The Great Grid Upgrade

Bramford to Twinstead Reinforcemen

Document 8.3.9: Applicant's Response to Issue Specific Hearing 1
Action Points

Final Issue A
September 2023

ELEVATION - A
 SCALE 1:150

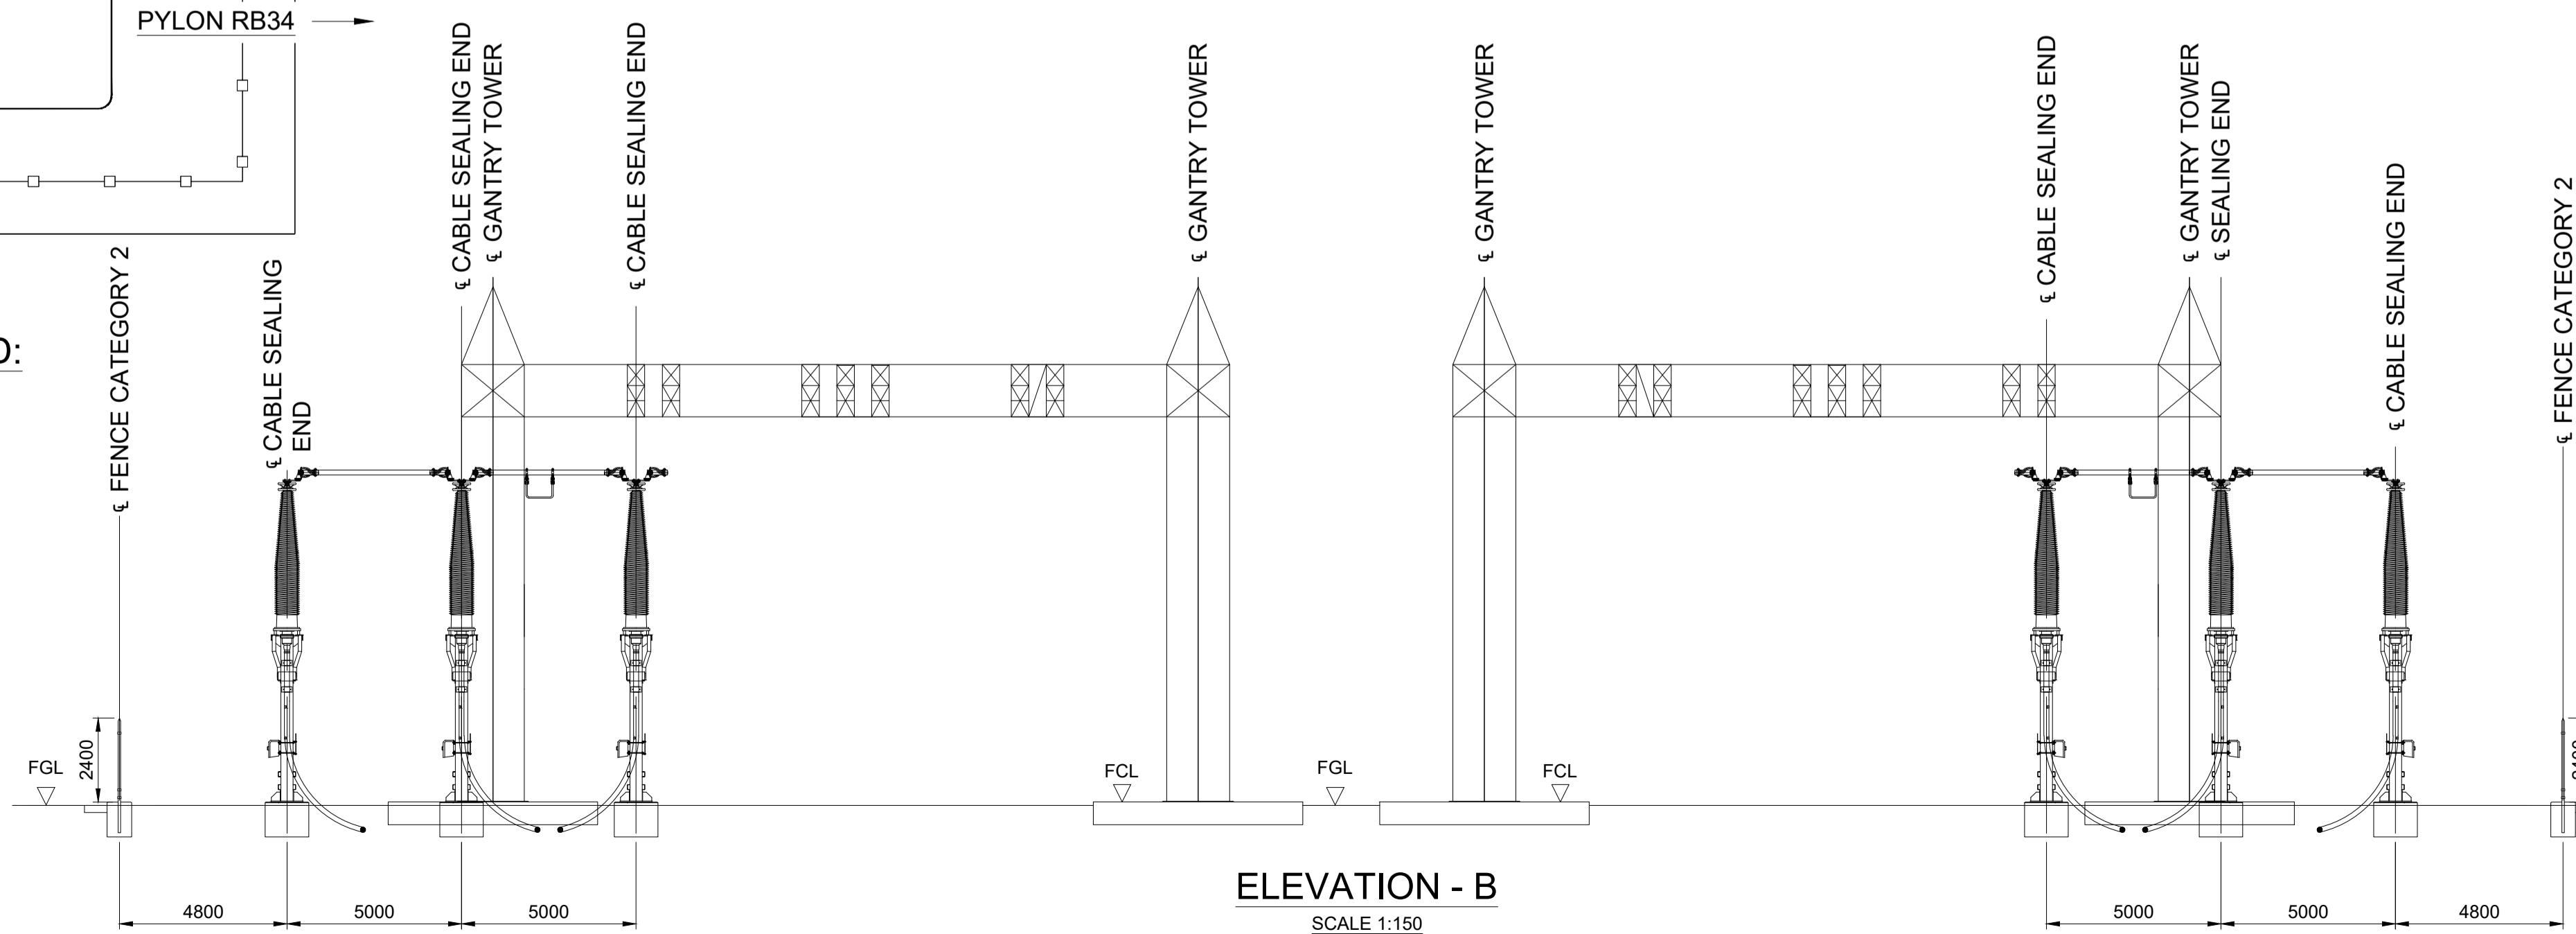
documents.	However, it is noted that the Explanatory Memorandum [APP-035] states (at paragraph 4.1.21) that 'Work Number 7 (shown on Sheets 21, 27 and 28 of the Work Plans) is concerned with the removal of approximately 2.5 kilometres of existing overhead electricity transmission line (Route 4YLA) between the Twinstead Tee and a point to the southwest of Alphamstone (indicated as 4YLA007 on Sheet 28 of the Work Plans).'	
		Essentially, the additional 0.5km (approximate) stated length of 400kV overhead line relates to the length of 400kV overhead line south of the Stour Valley West CSE compound, which whilst this 0.5km (approximate) length is being removed; it is being removed to be realigned in this section.	
		This realignment of the existing 400kV overhead line (as opposed to the in-isolation removal of the overhead line) is described in Work Number 6 of the draft DCO [APP-034] and shown on Sheets 27 and 28 of the Works Plans [APP-010].

The 'non-linear works' (those which are not the linear overhead line nor the linear underground cable) are listed in principal at article 5 (Limits of deviation) of the draft DCO [APP-034] at article 5(3) being the 'other permanent above ground structures, erections and apparatus, including substations and cable sealing end compounds'. Article 5(3)(a) refers to 'any applicable non-linear limits of deviation shown on the Works Plans'.	
		The Applicant, therefore, is the view that the works are properly controlled by the Work Plans and associated draft DCO [APP-034] article 5 in respect of the LoD.	
		To assist the reader, the General Arrangement Plans [APP-018] at Sheet 12 contain a label to this area (pointing to the black lined box which the legend confirms is a 'cable sealing end compound') stating 'Refer to drawing: 2.11.5 Design and Layout Plans: Dedham Vale East Cable Sealing End Compound'.
